Re: Oxbow and Coors Pavilion Developments Appeal at NM 45 and St. Joseph's Drive

I received your request for appeal to NMDOT District Three's non-concurrence on the Oxbow and Coors Pavilion Development Traffic Impact Study (TIS) as submitted. According to the letter dated August 15, 2022, NMDOT has concerns with the safety operations at NM 45 (Coors Blvd) and St. Joseph's Drive. NMDOT strives to maintain a multimodal facility at its highest level of safety, therefore meeting the minimum levels of services as outlined in the State Access Management Manual.

Justin Gibson, PE  
District Engineer  
NMDOT District Three

NAME: N:\Projects\W0007_Skarsgard\W0007_0004_Skarsgard\Odobow_Centim3_CAD\Sheets\8 ROAD X SECTIONS.dwg Plotted: May 13, 2024 2:50pm USB John Stapleton

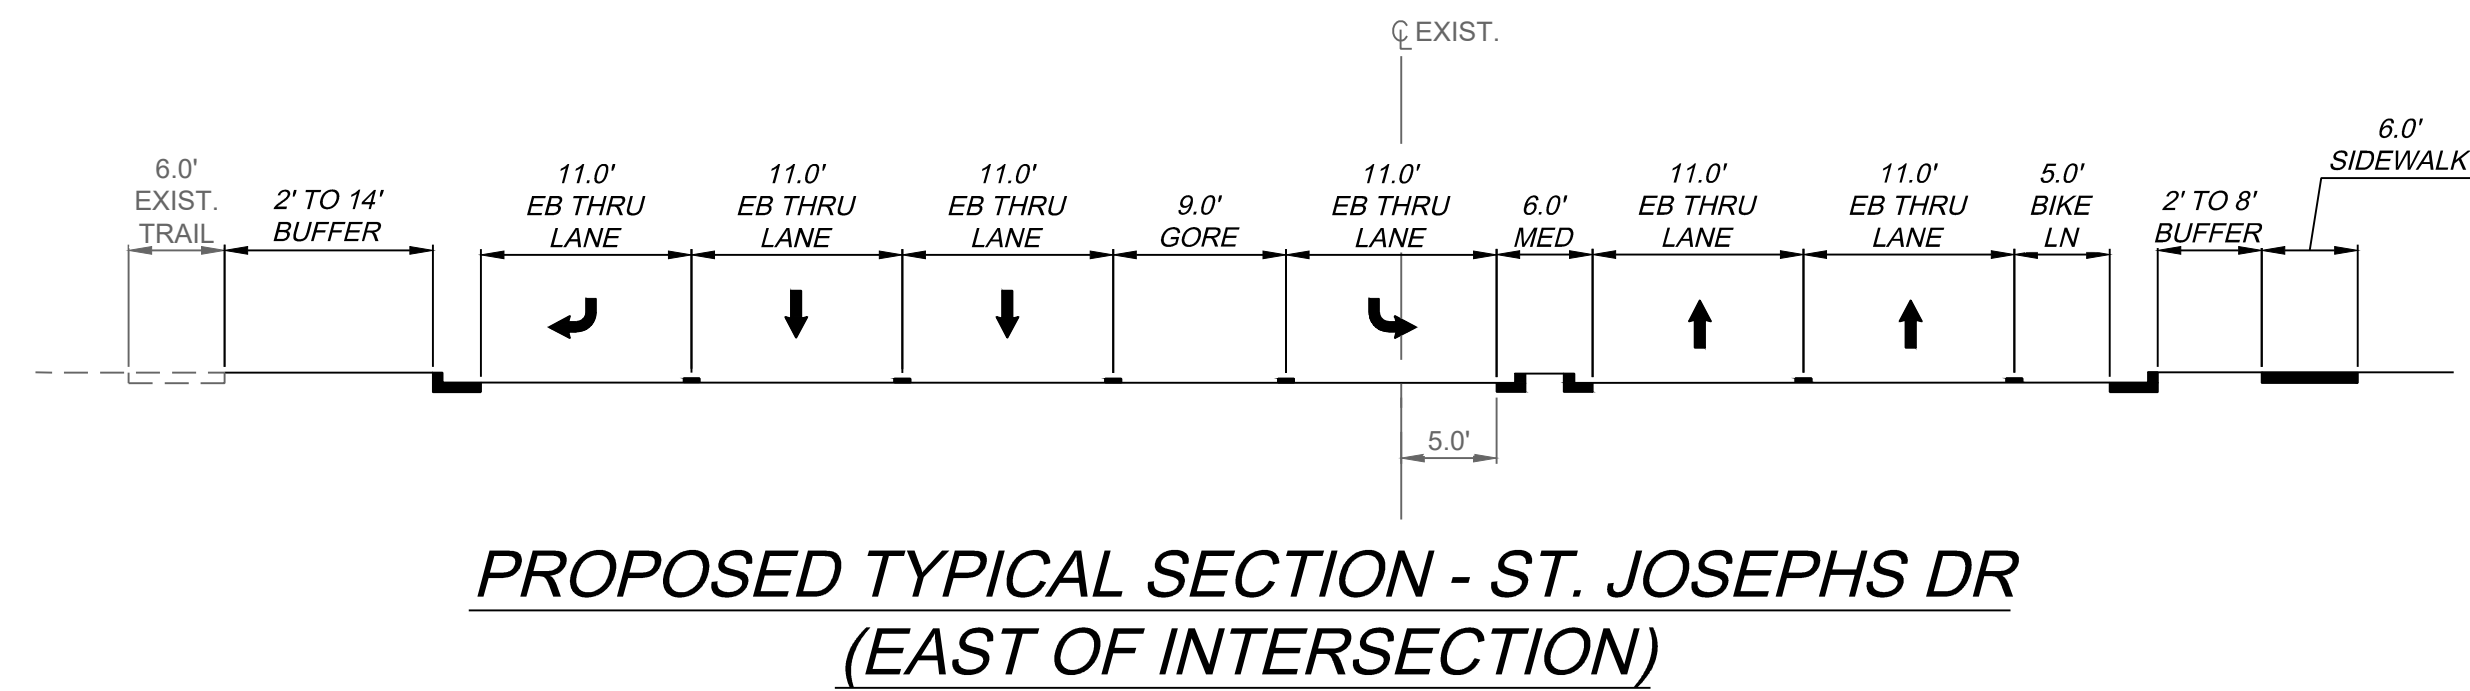
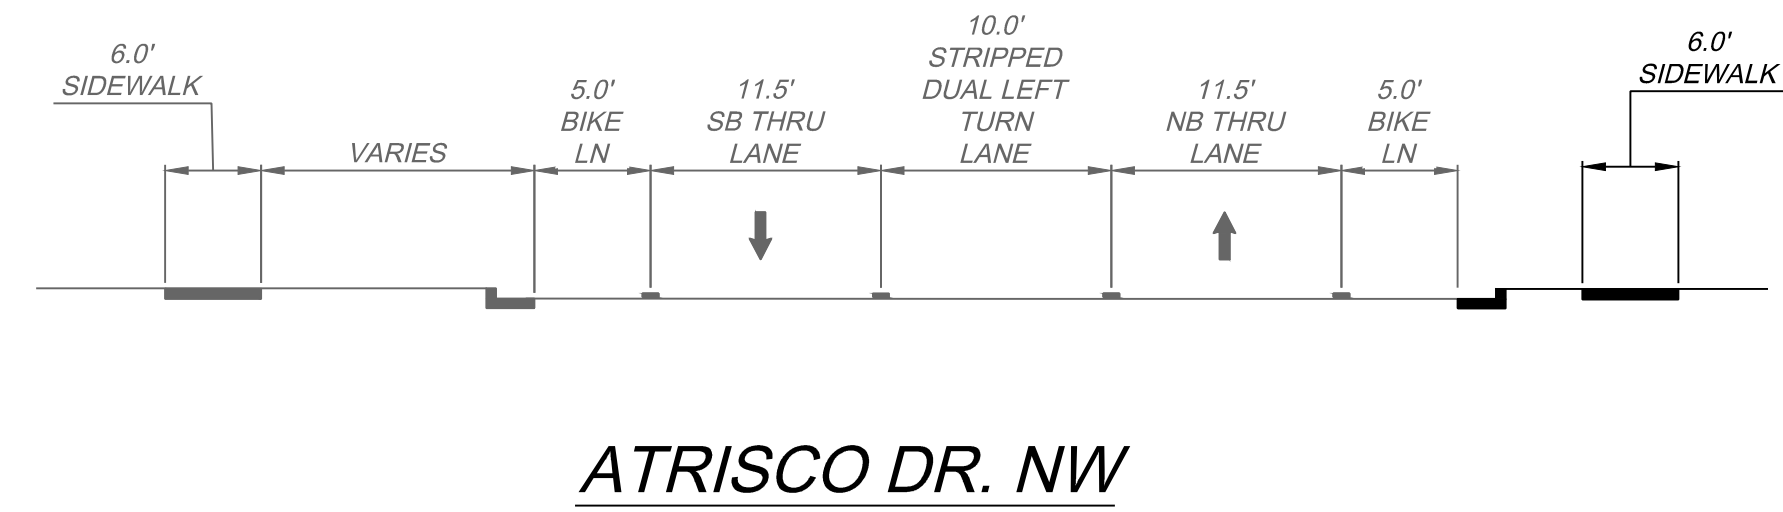
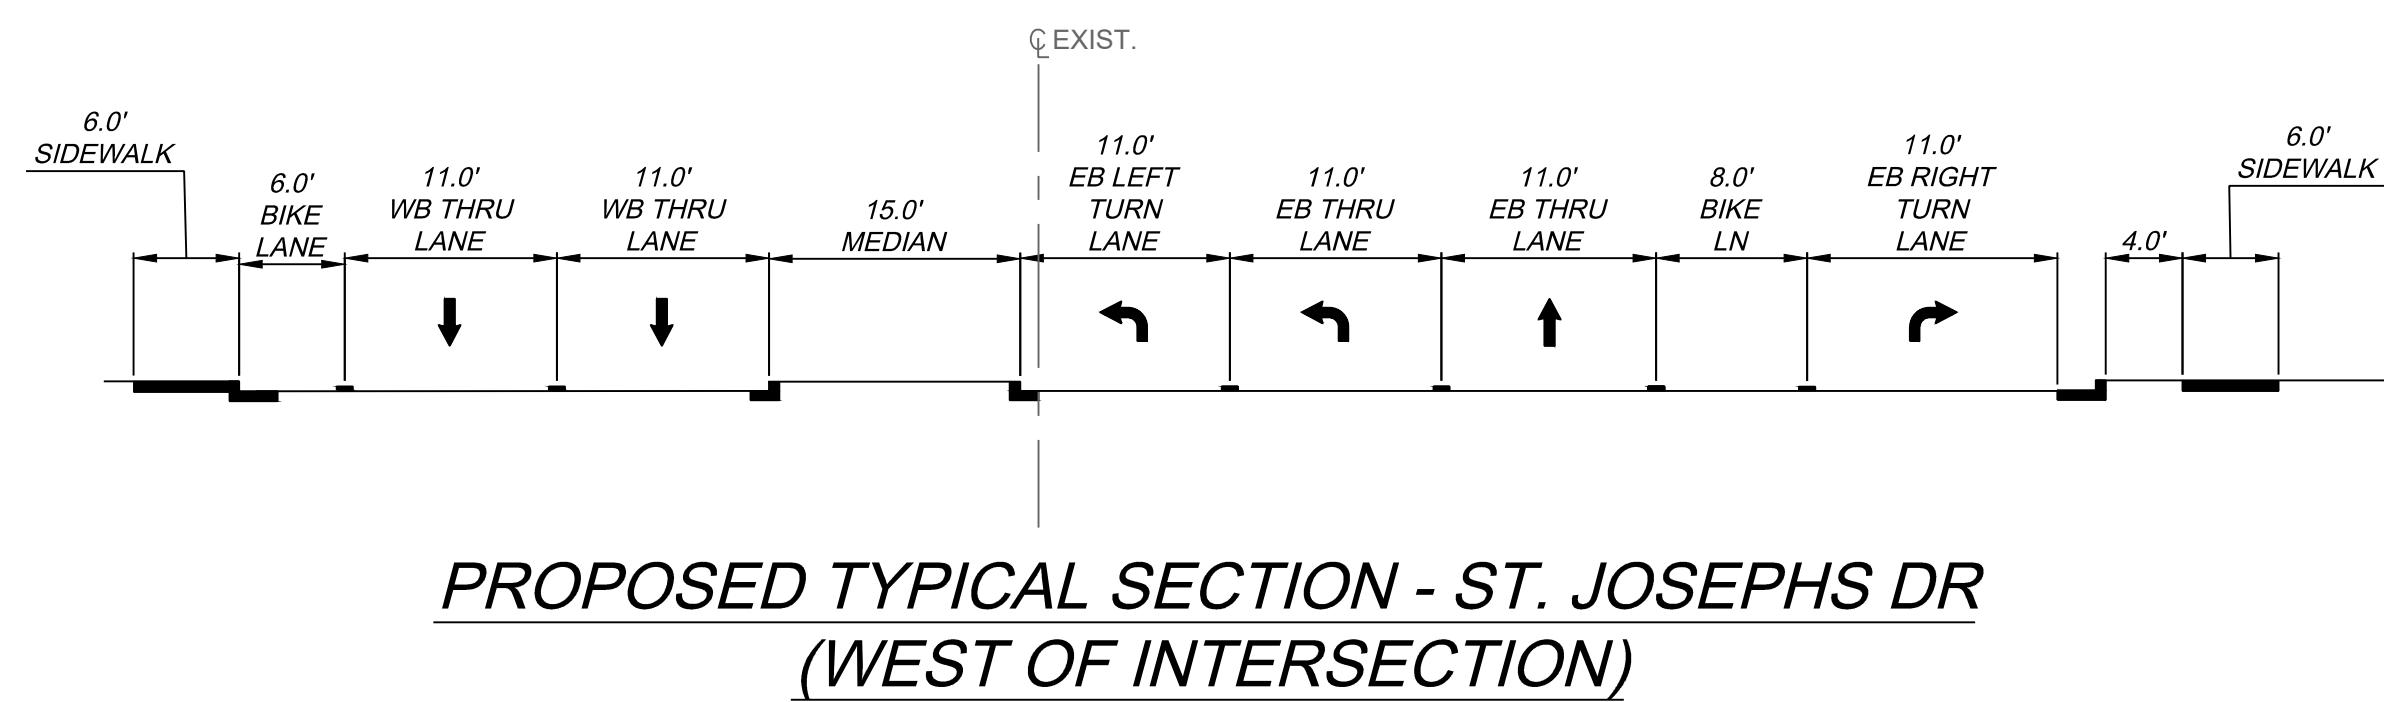
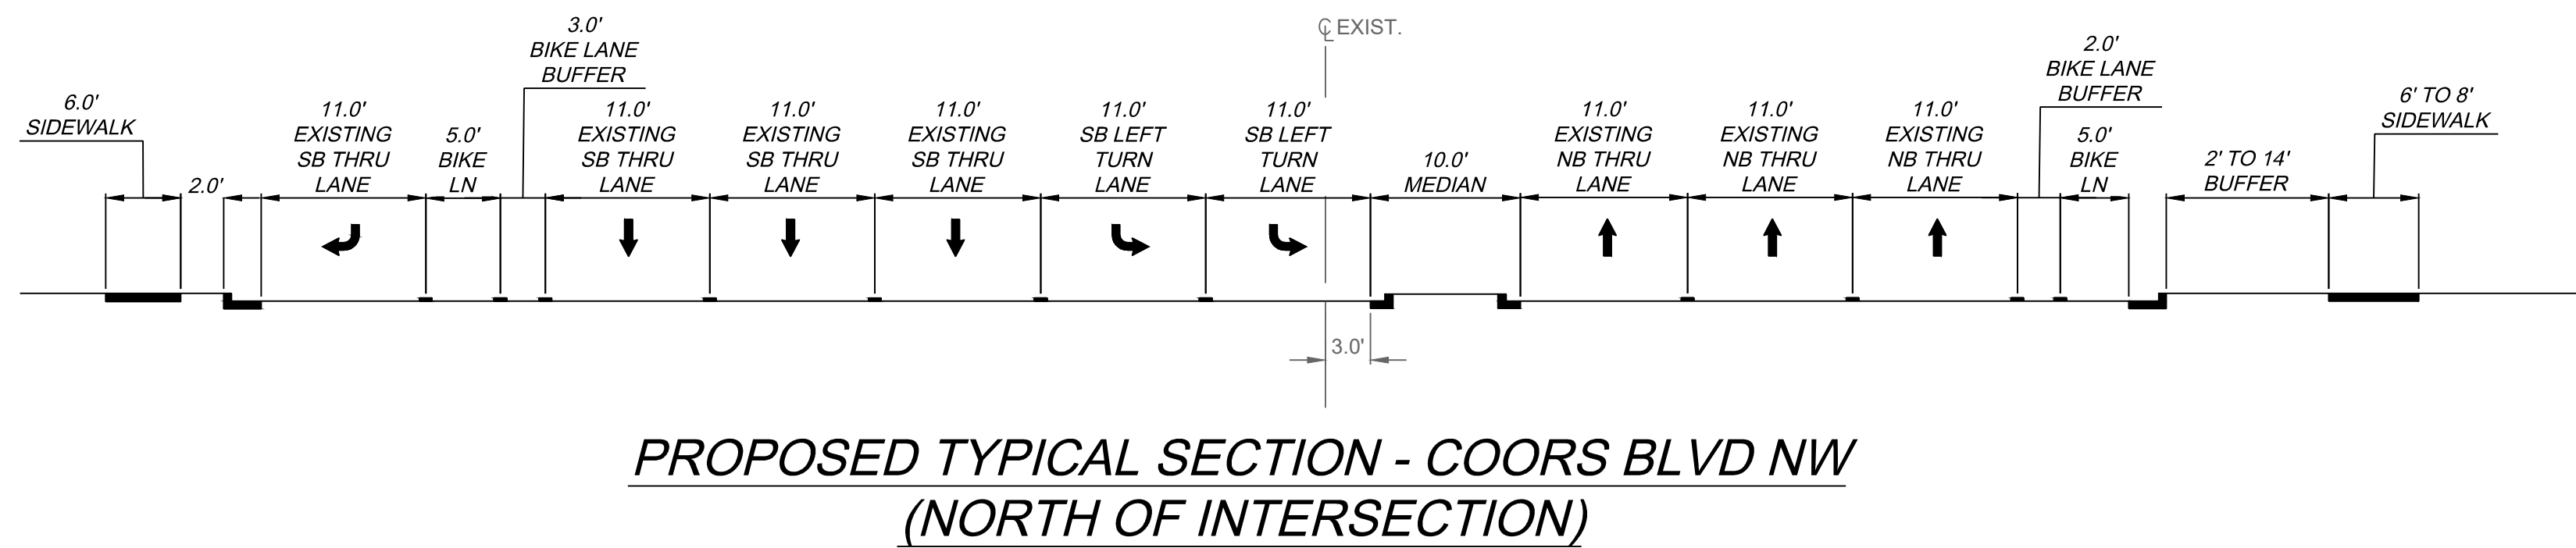
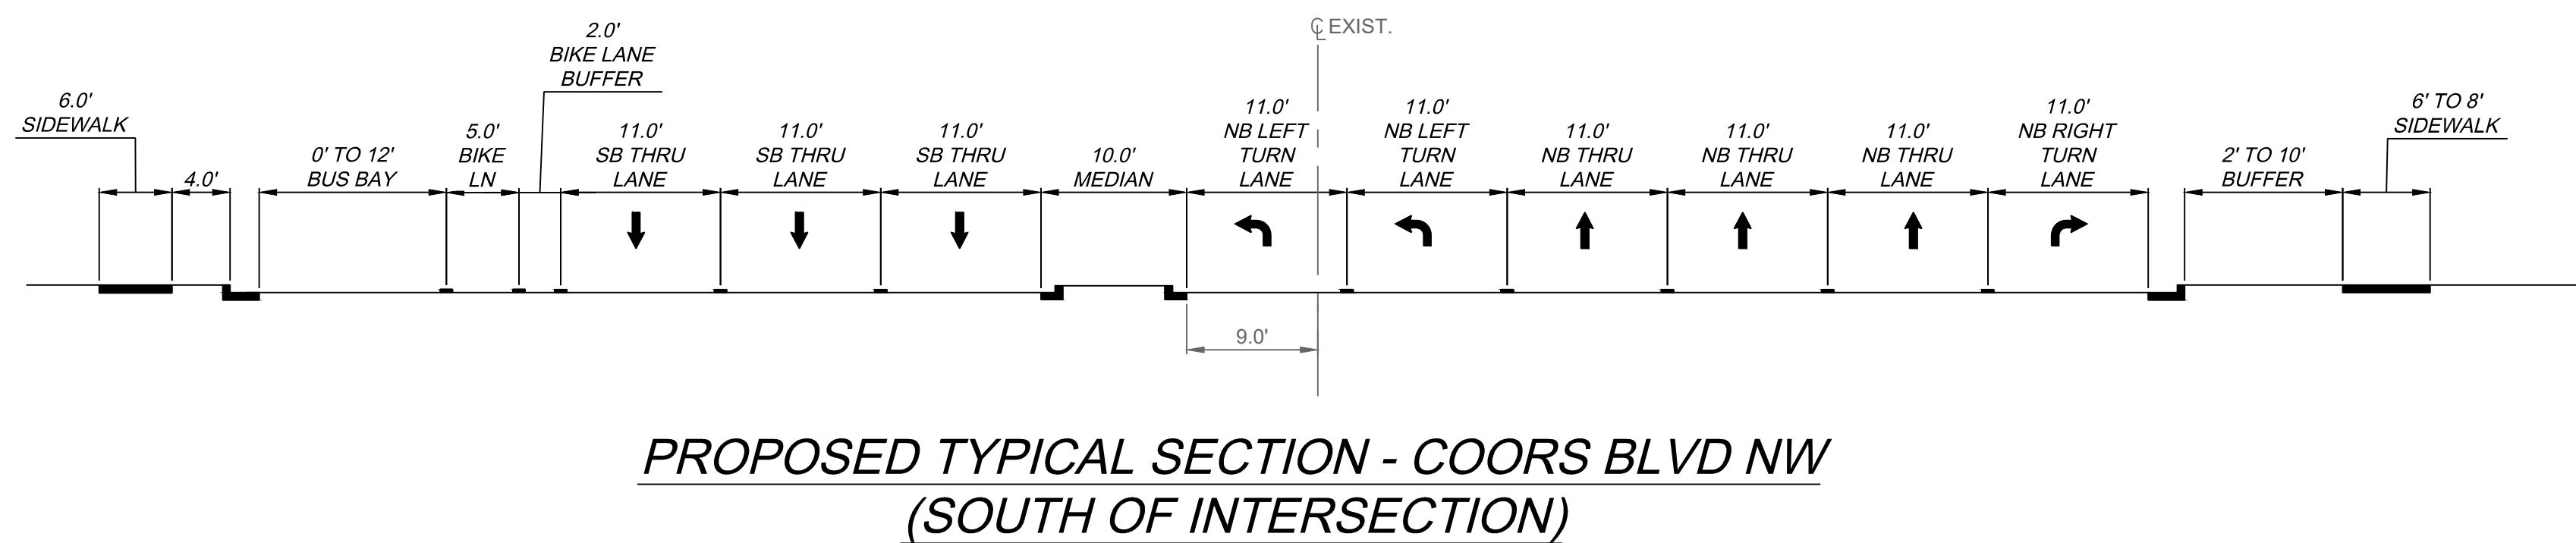
- The development shall propose a design on NM 45 that meets NMDOT's design standards for lane widths, median widths and design turning templates.
- The development shall obtain professional engineering services who are qualified to provide oversight of the signal operations and management on NM 45 at the signalized intersections of Western Trail, St Joseph's Drive and Sequoia Rd. This work shall include daily/weekly monitoring and management of the signal operations for the duration of construction of this development through the full build of this development plus one year. This work may be performed utilizing the existing Automated Traffic Signal Performance Measures (ATSPM) System owned by the City of Albuquerque.
